MEMORANDUM

FROM: Jeff Rice, PCD-Engineering
719-520-7877

SUBJECT: SF-22-025 – Eagle Rising **Response to Memo 8/1/2024**
Fourth response to comments

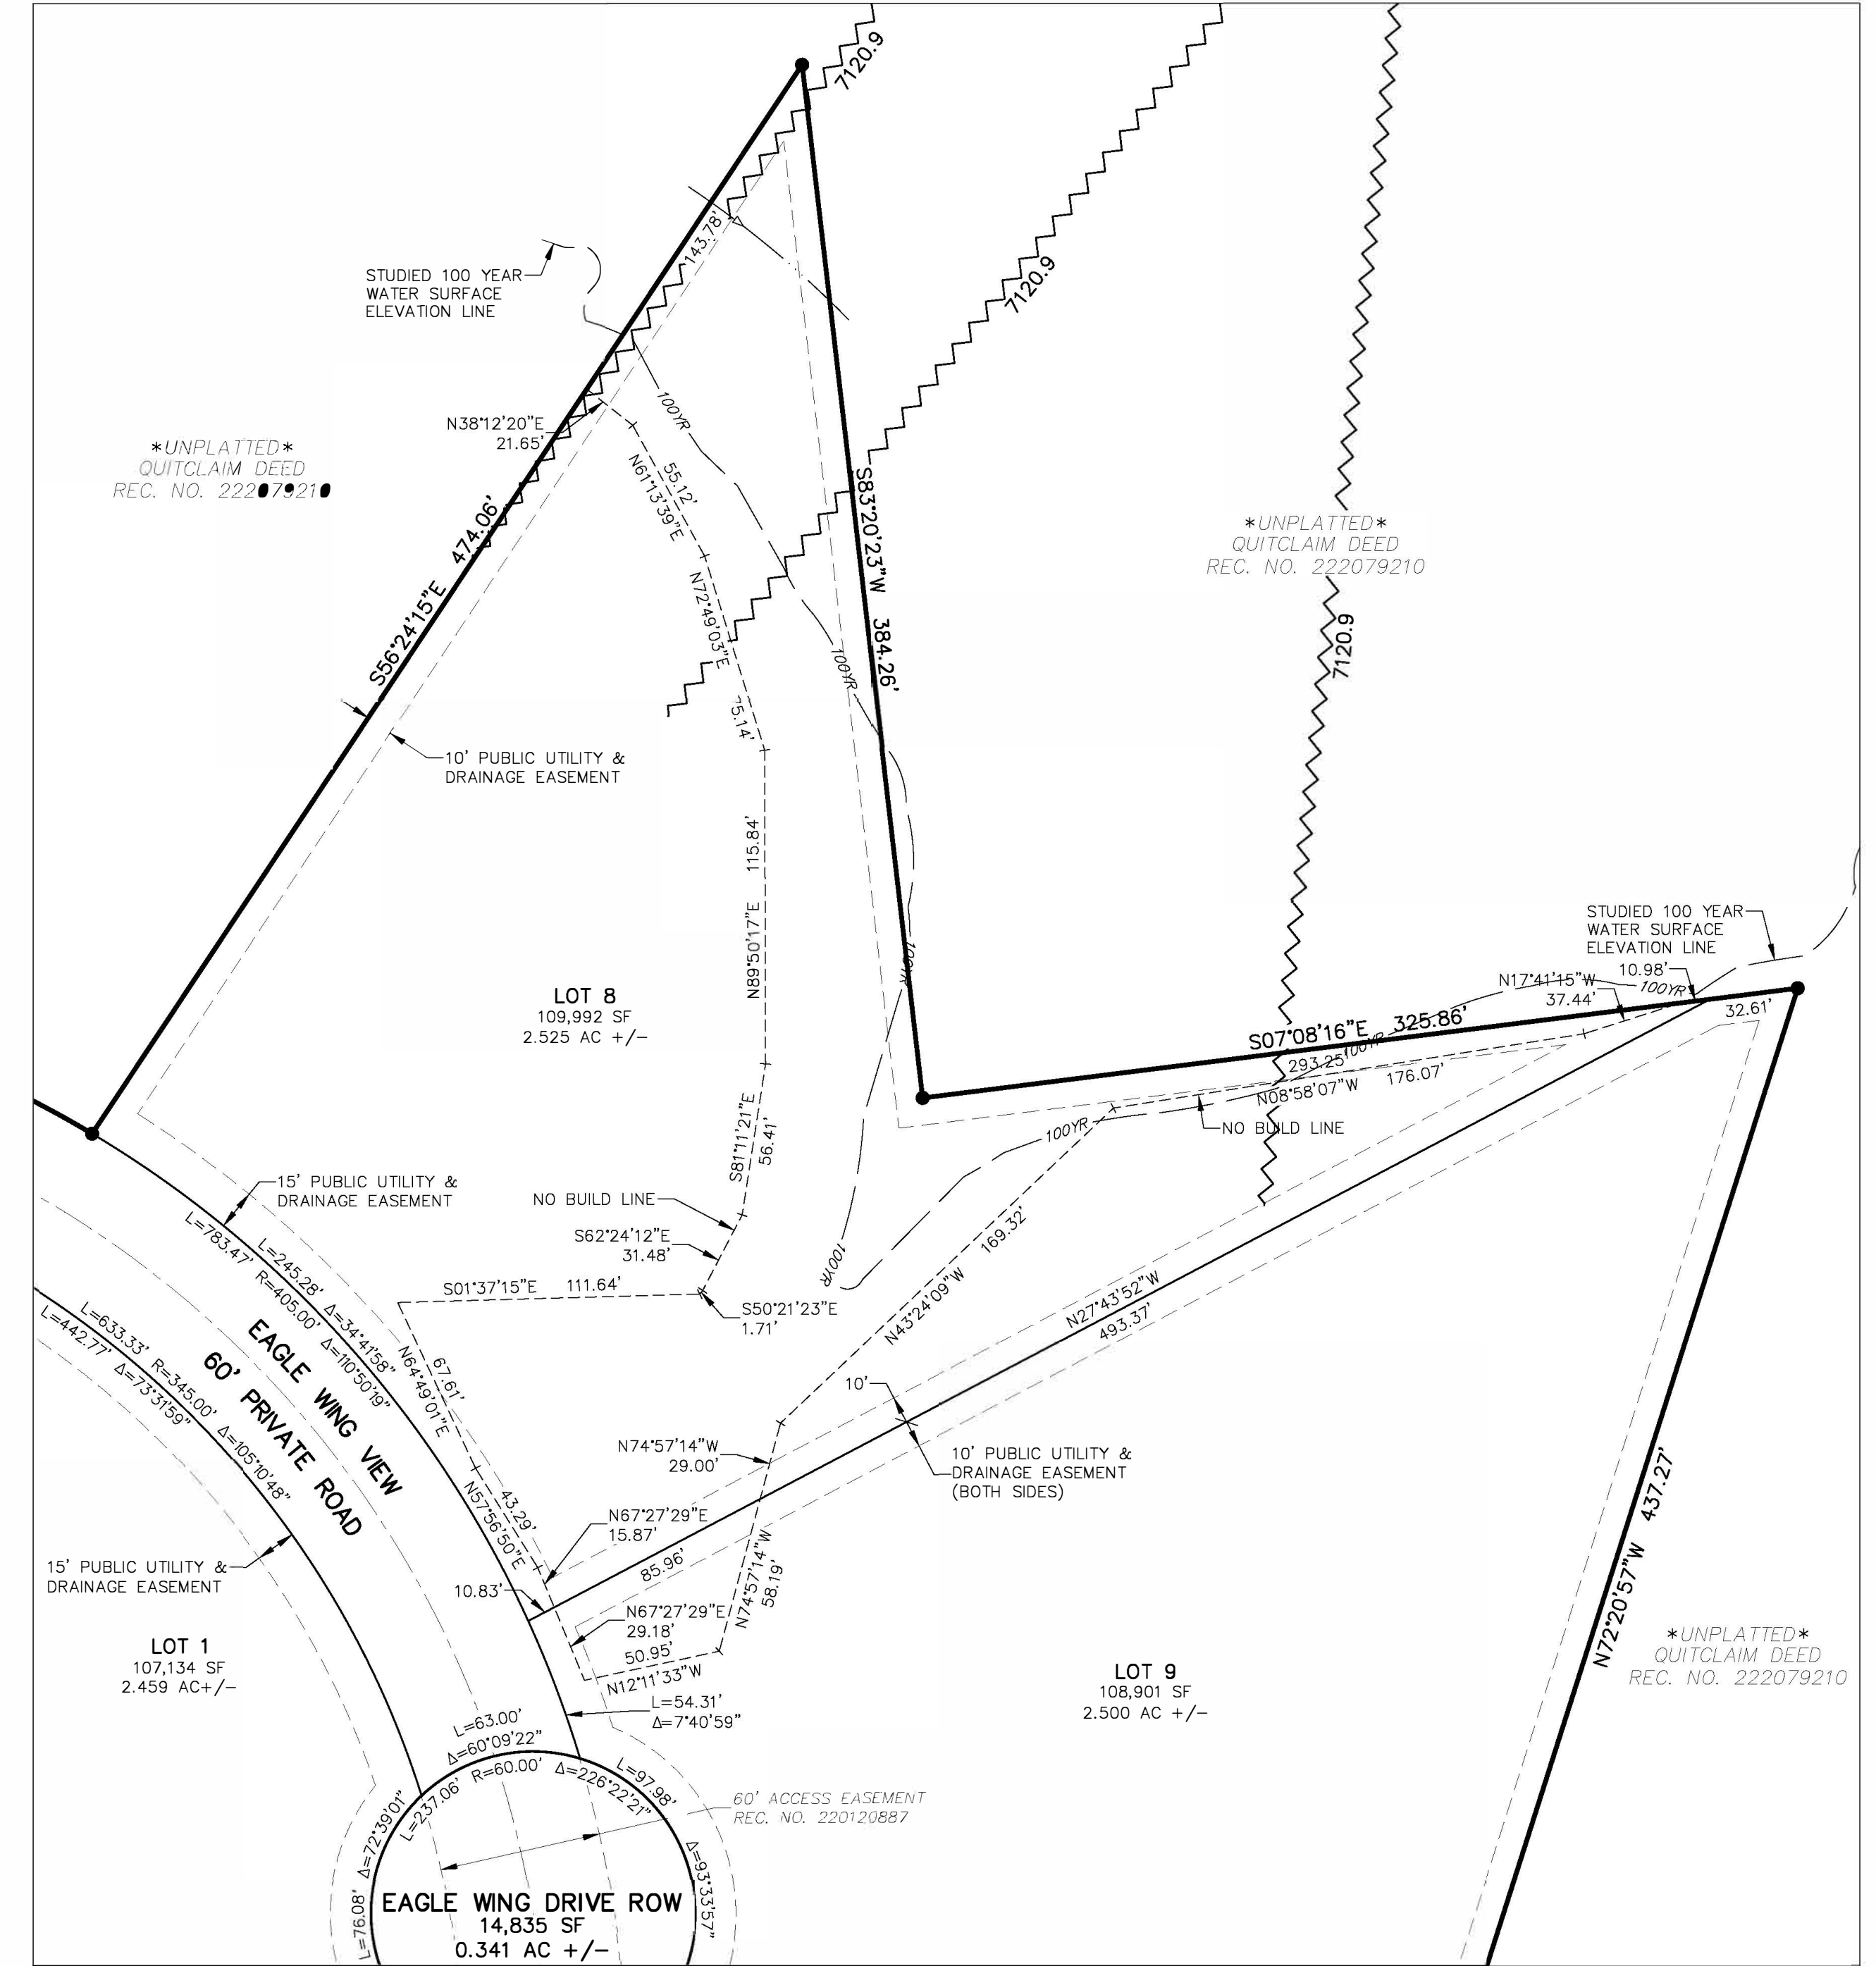
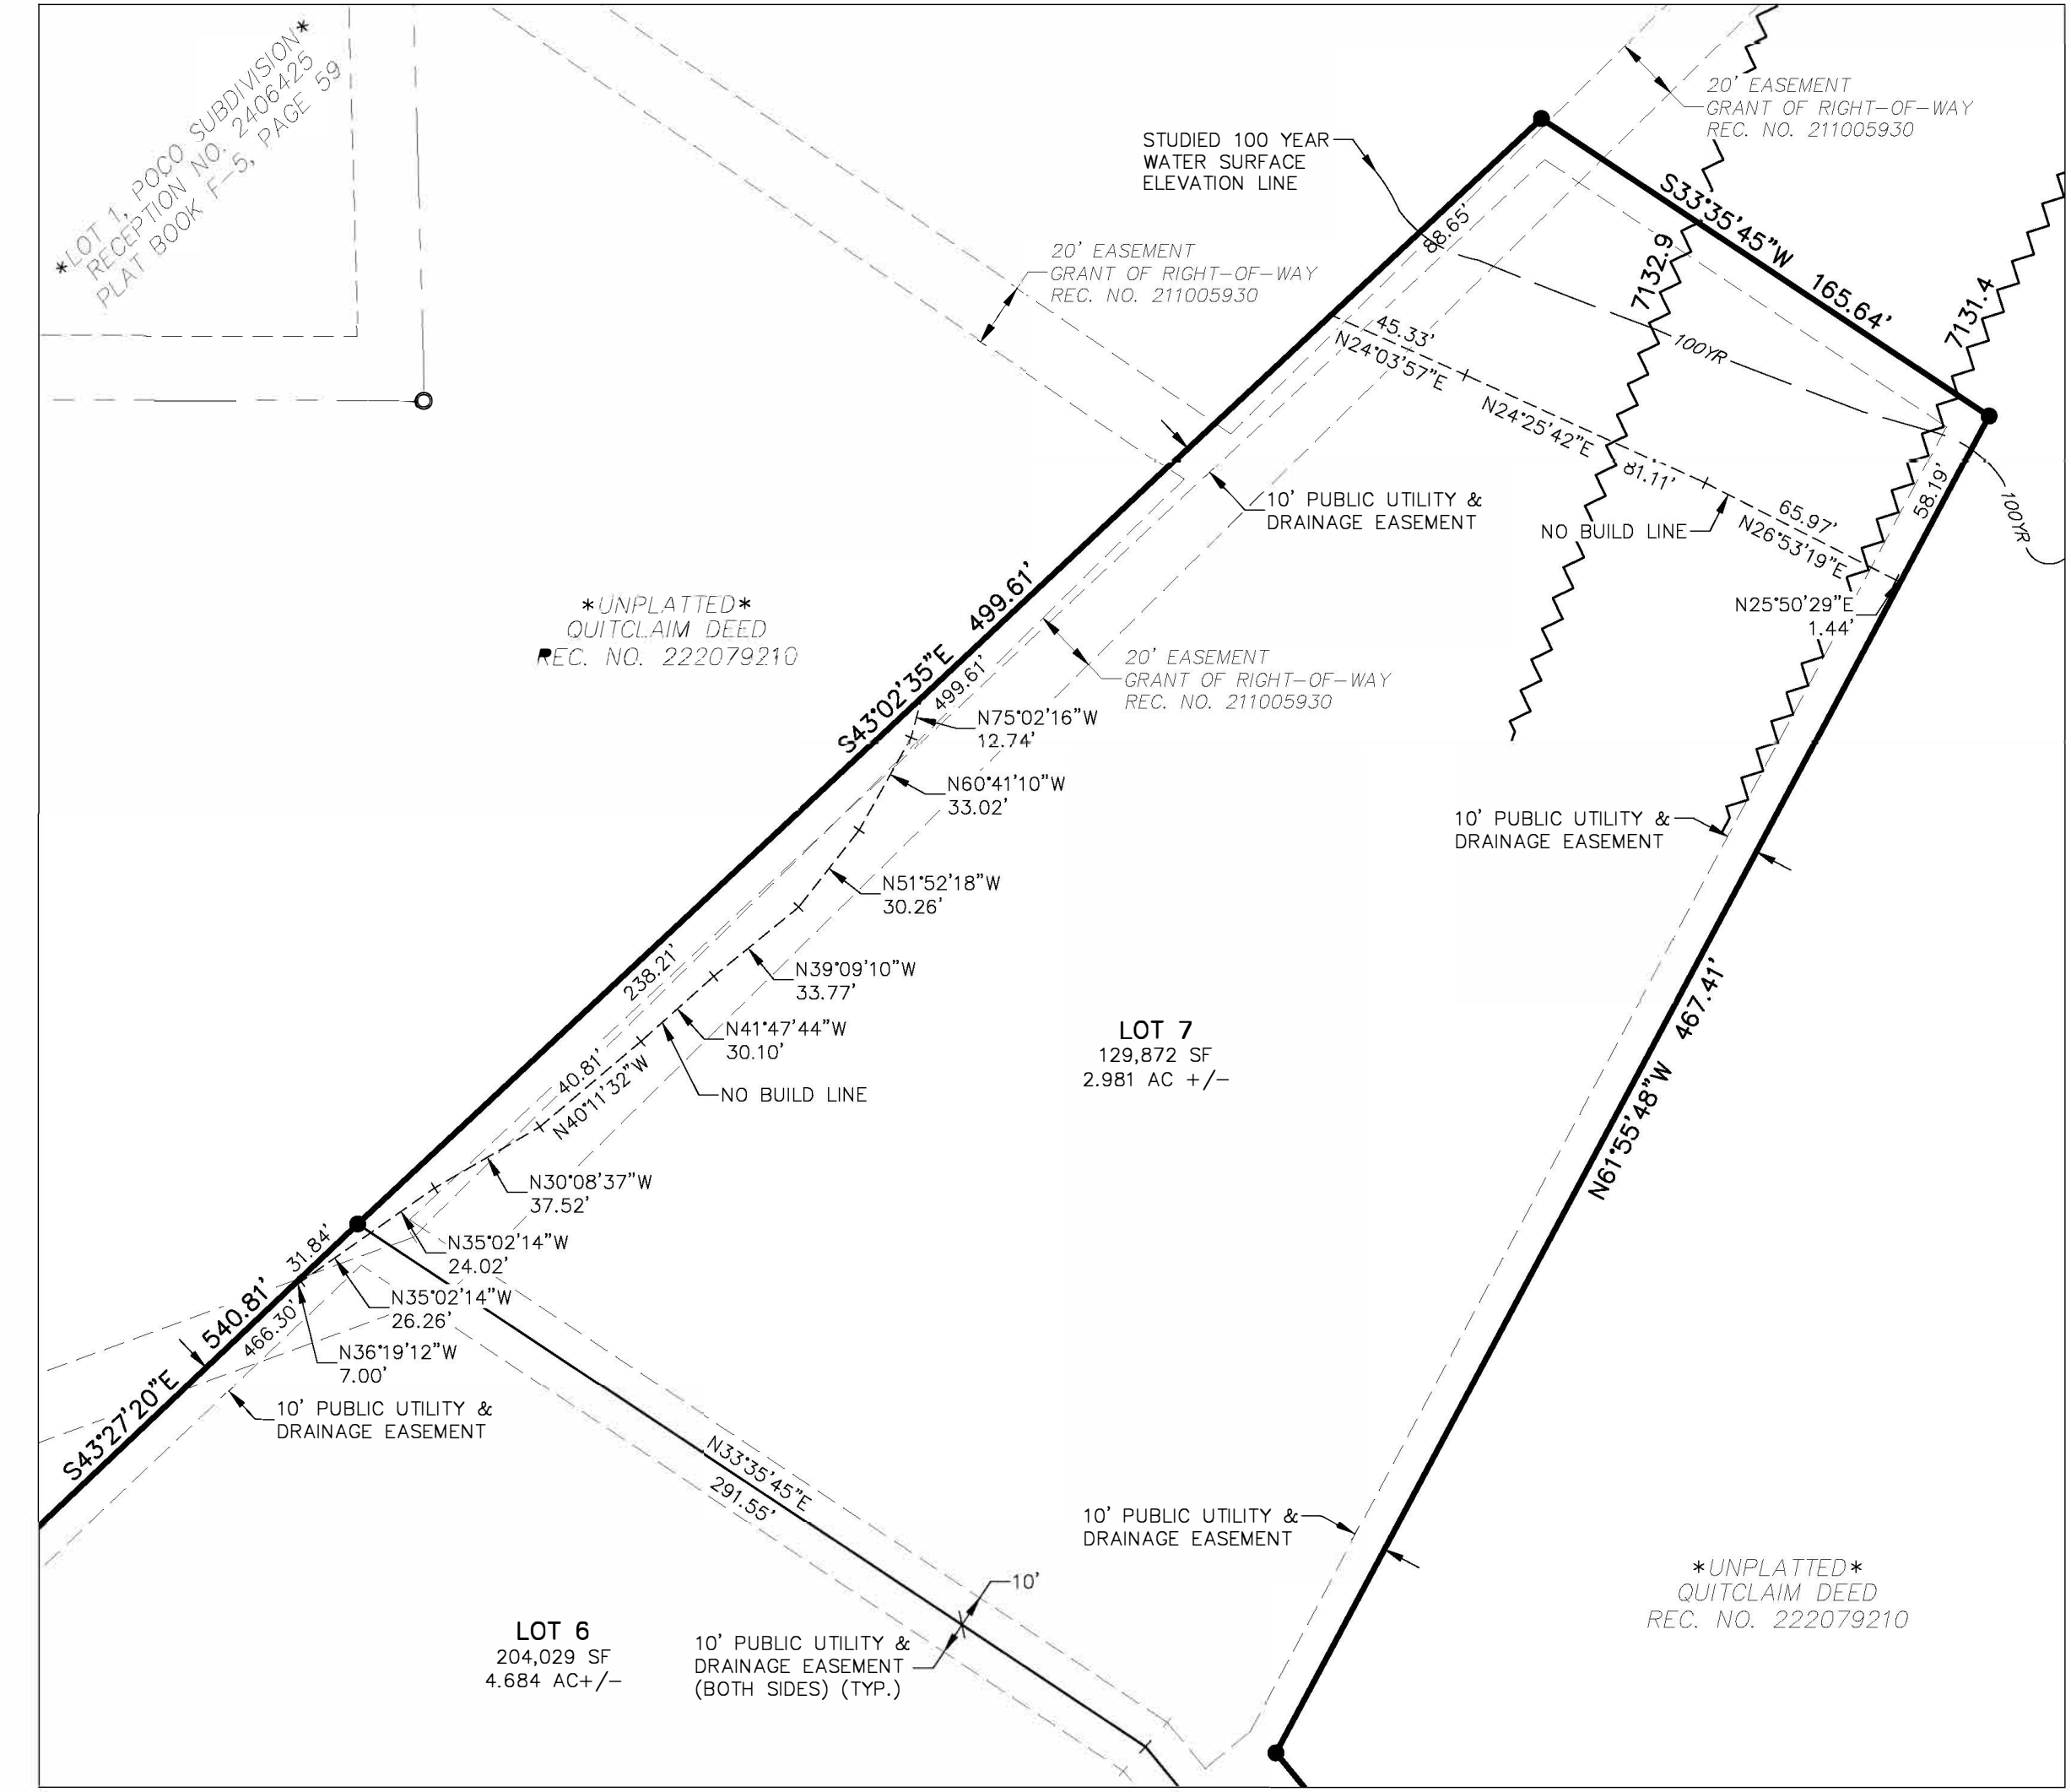
2. Floodplain elevations at each lot need to be addressed in accordance with LDC Section 8.4.2(B) and DCM Section 1.4.2. Based on the HEC-RAS modeling, provide the maximum calculated 100-year floodplain elevation at each applicable lot corner either on the plat or on a plan (GEC, FDR, etc.) that can be referenced with a plat note.

- a. Provide a plat note stating that structures are to be constructed a minimum of one foot above the highest calculated floodplain elevation. Resolved.
